Summary of Comments on P:\100\100.051\prelim plan\early grading\100.051early grading cover sheet C0.1 (1)

Summary of Comments on Microsoft Word - 100.051-swmp

CREEKSIDE SOUTH AT LORSON RANCH

PUD SP-20-001

SHEET NUMBER  
**C0.1**  
TOTAL SHEETS: 15

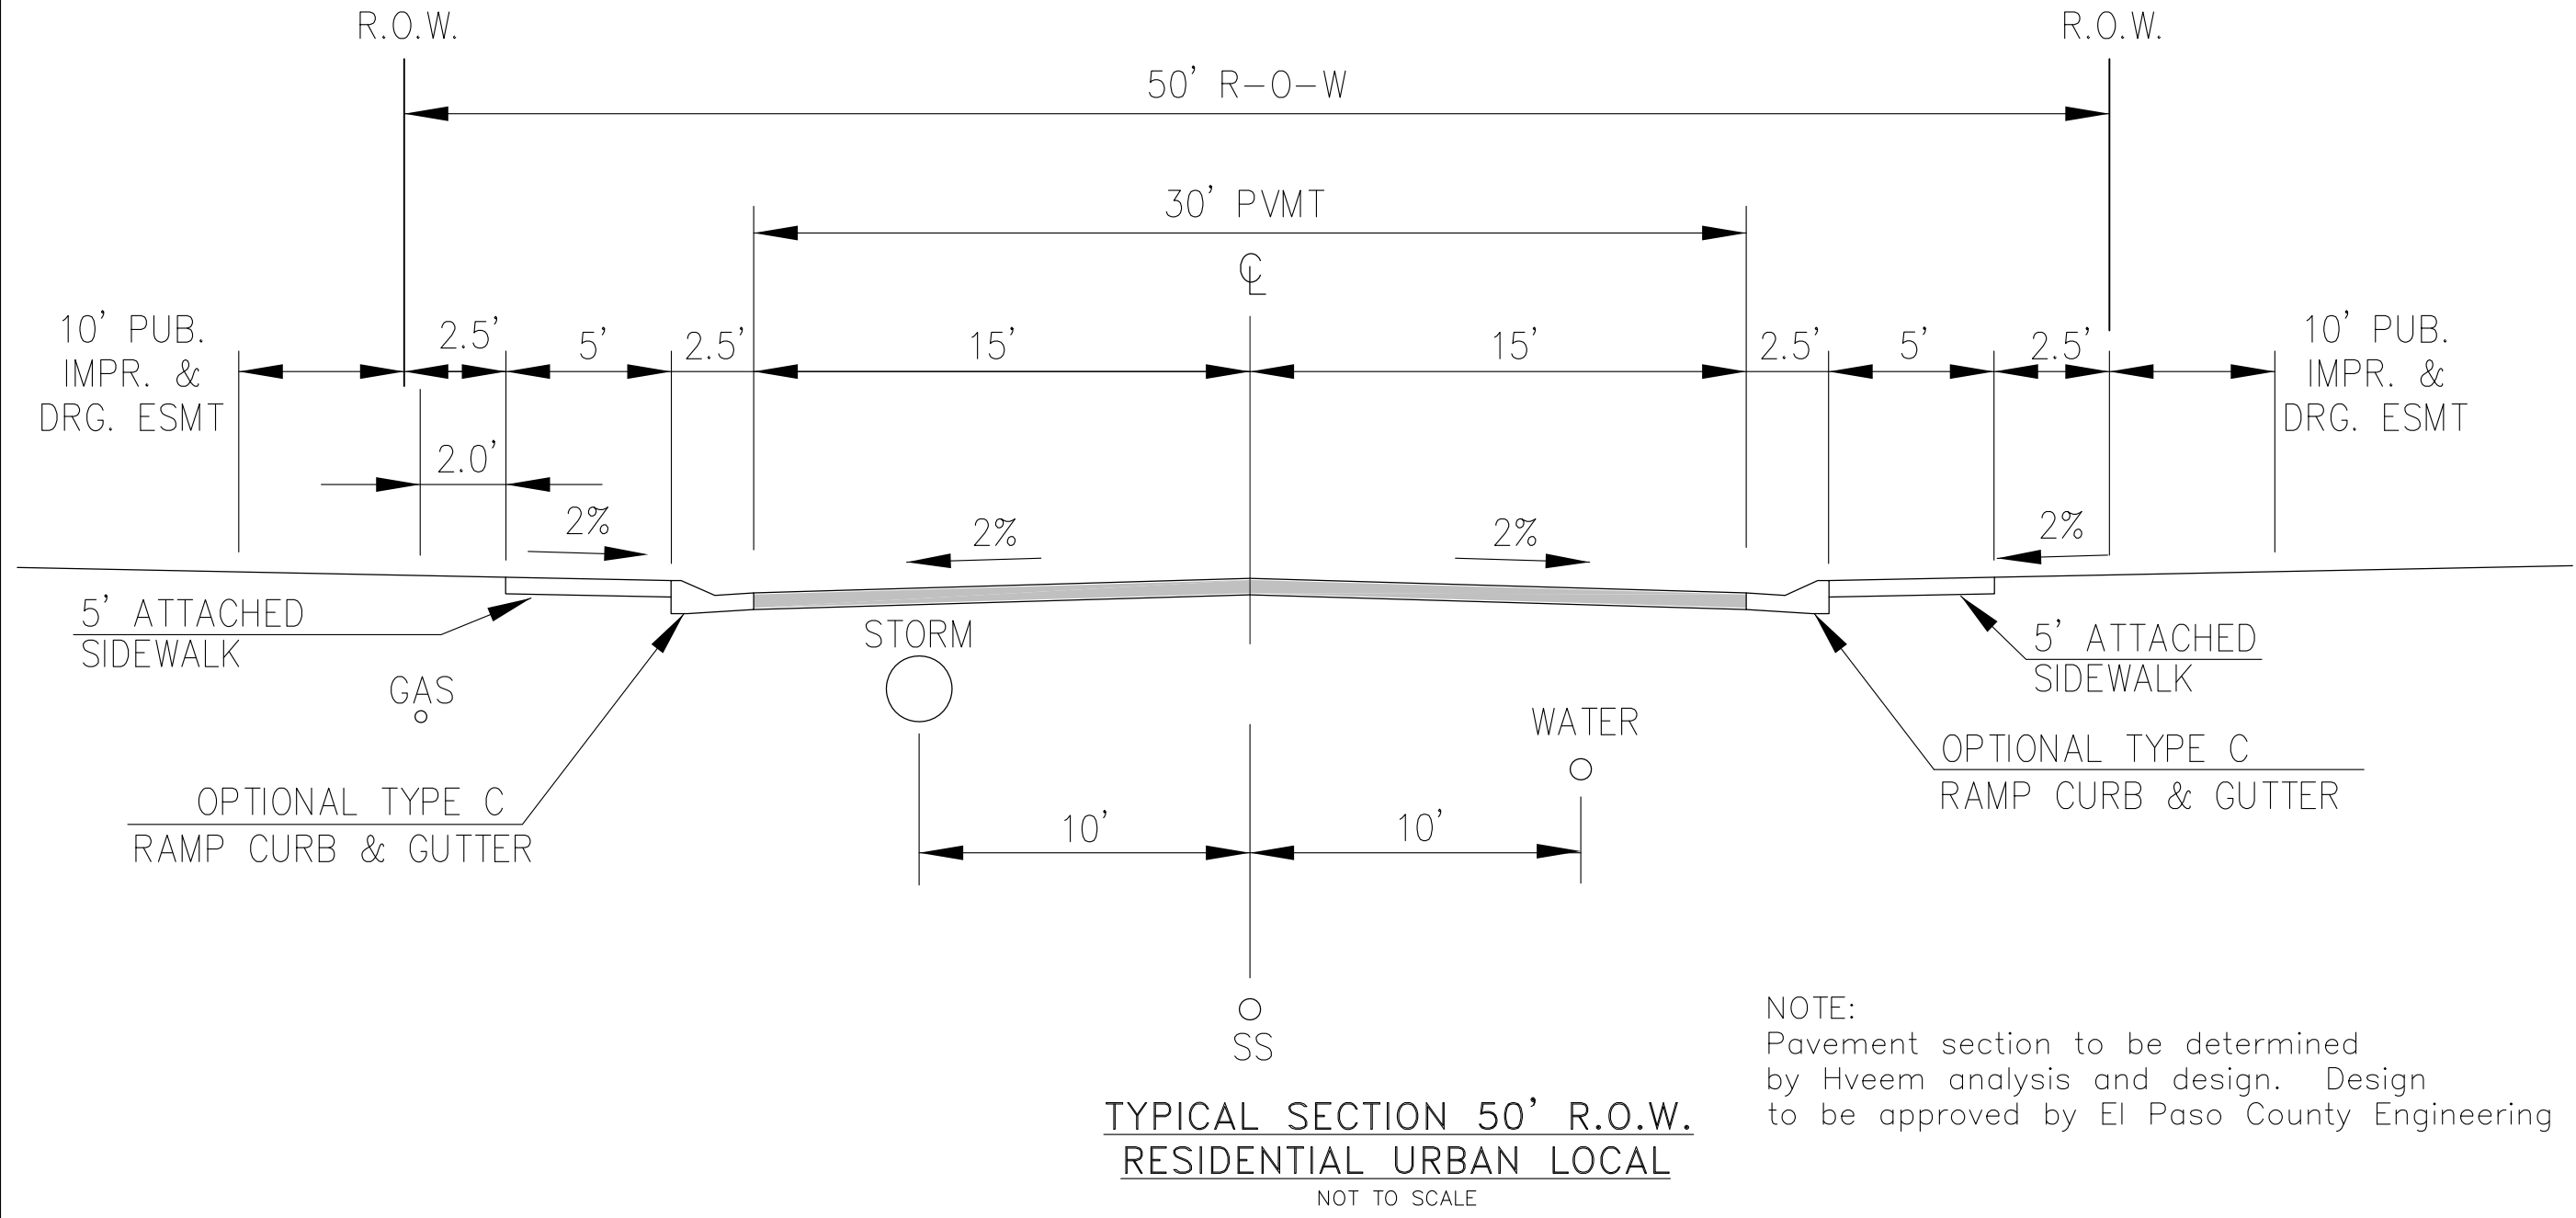
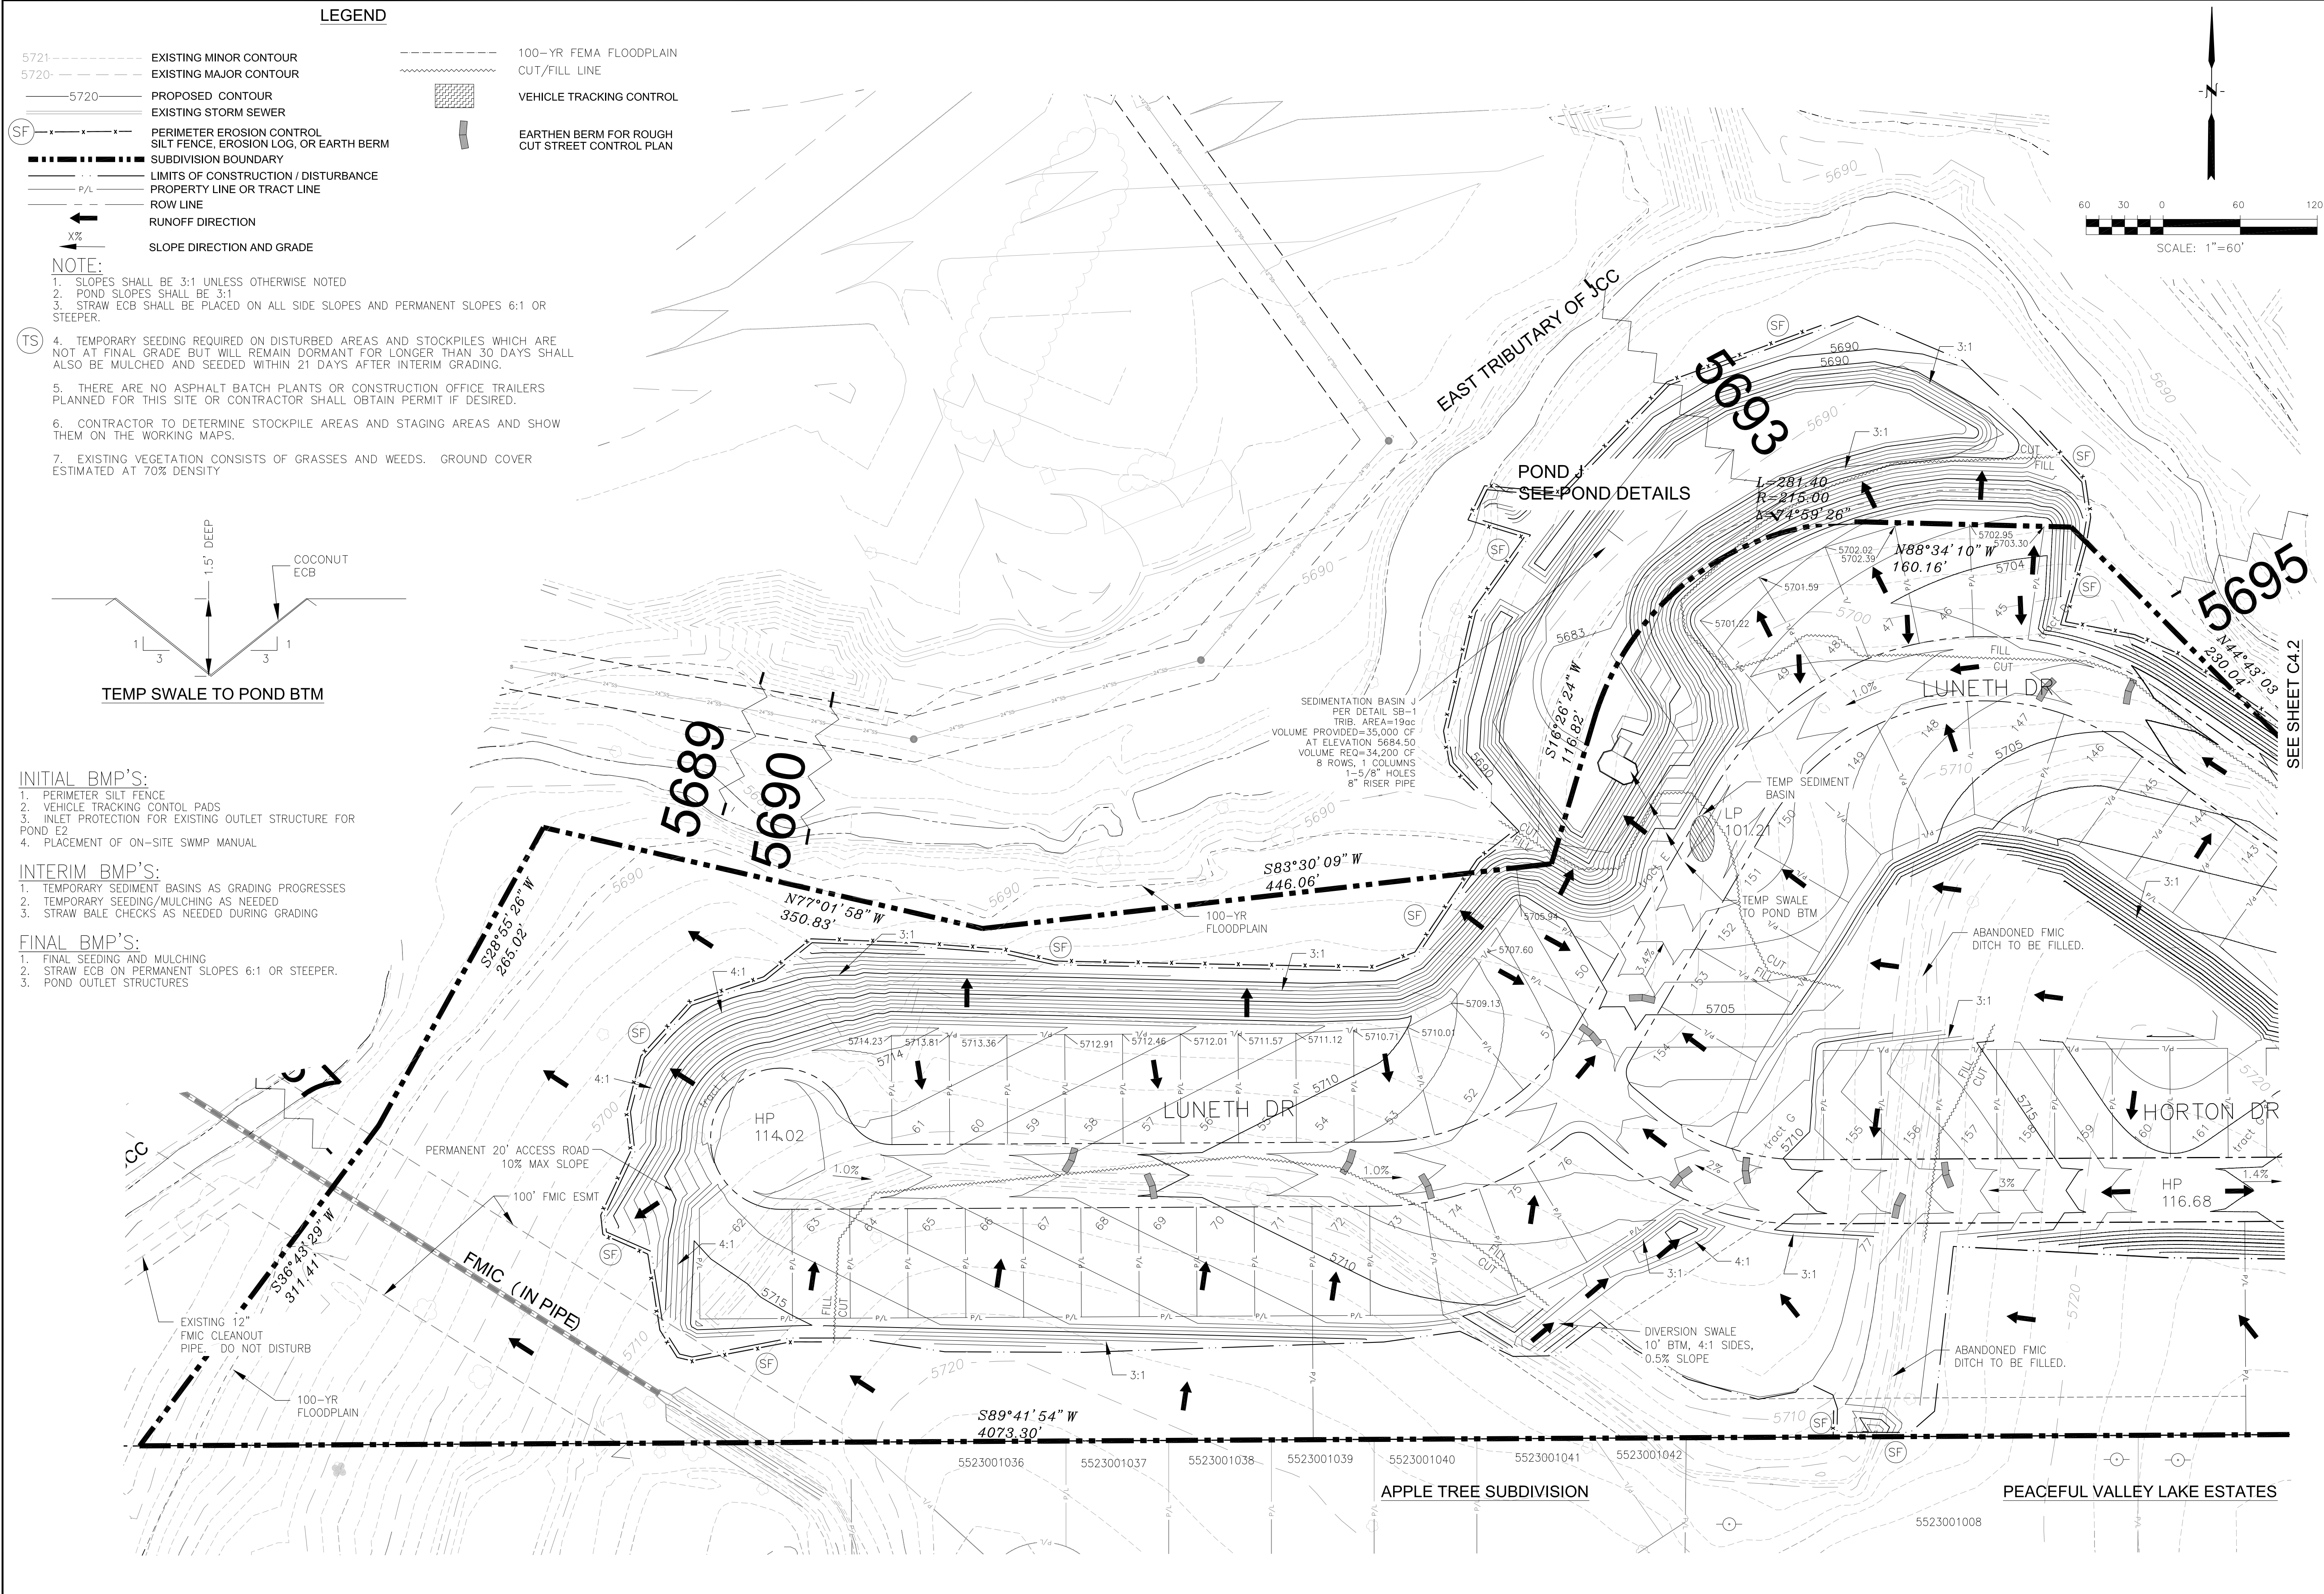
Update text to match GEC Checklist ii

Update text to match GEC Checklist Item JJ

NOTE: ALL CONCRETE FOR FOREBAY SHALL BE CDOT TYPE D

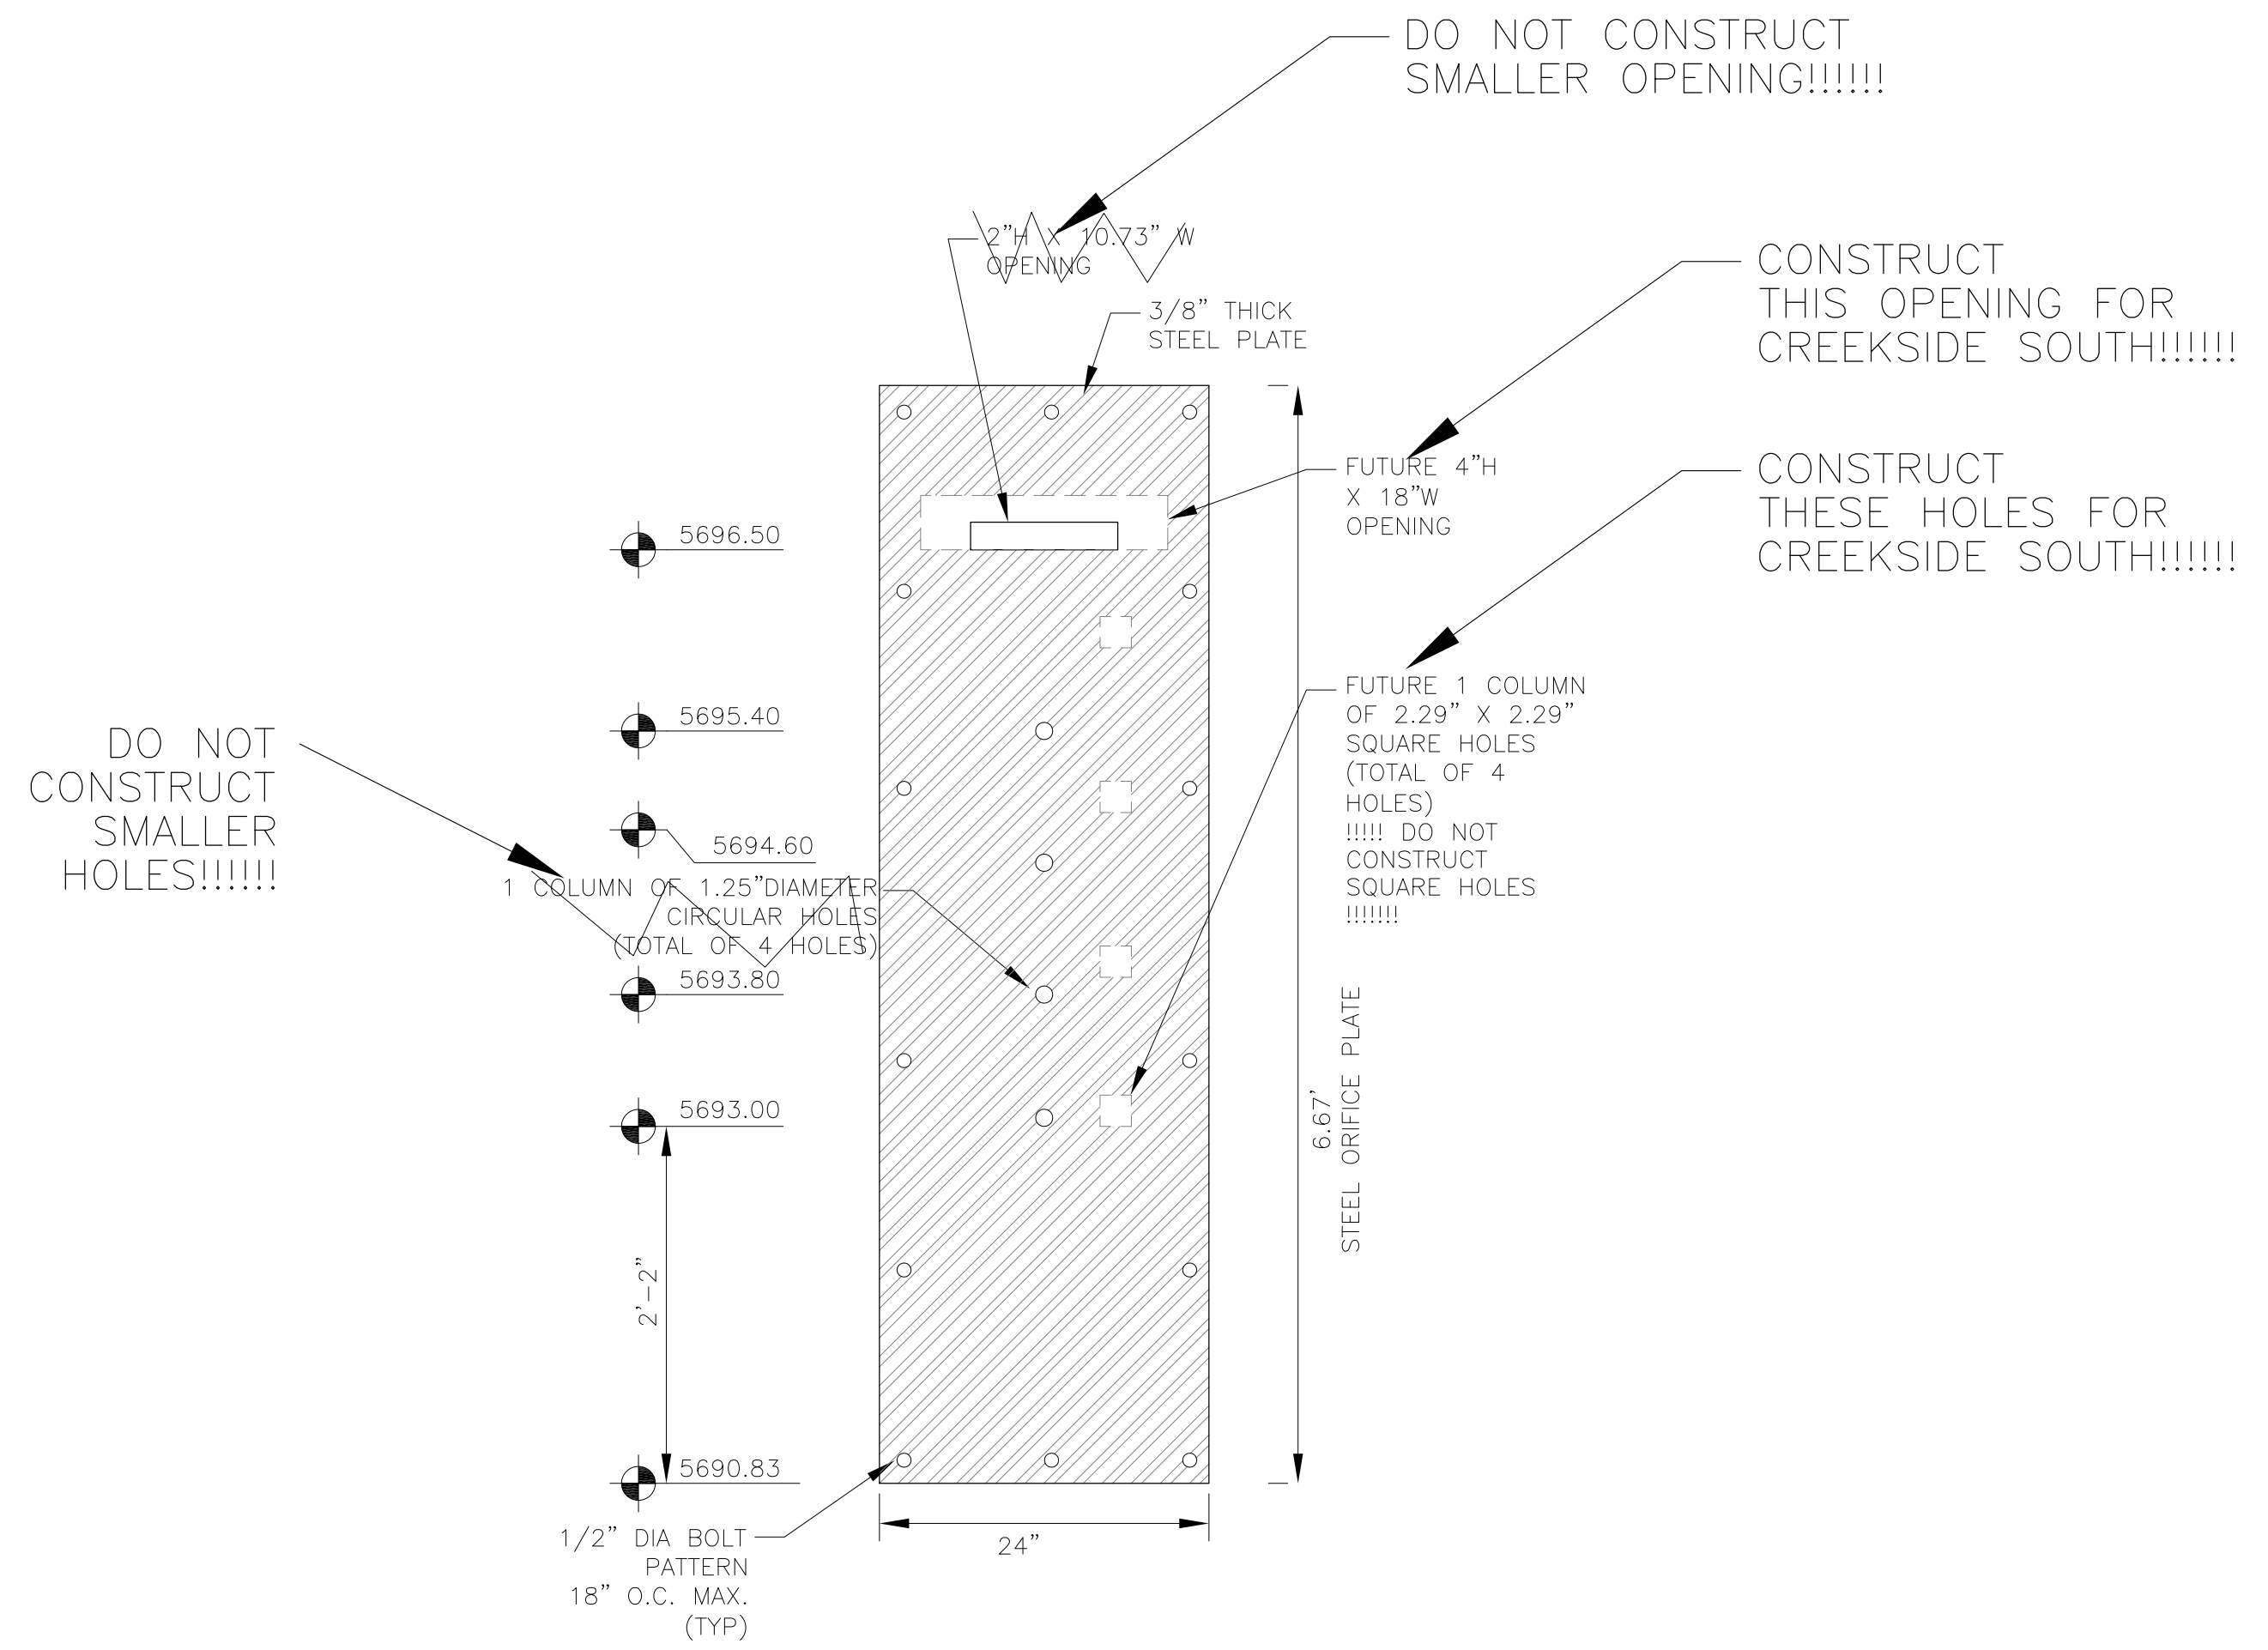
Author: Christina Furchak Subject: Engineer Date: 4/15/2020 3:54:40 PM
Provide gasket between plate and concrete to create watertight seal
Author: RSchindler Subject: Sticky Note Date: 5/11/2020 2:26:45 PM
GASKET ADDED
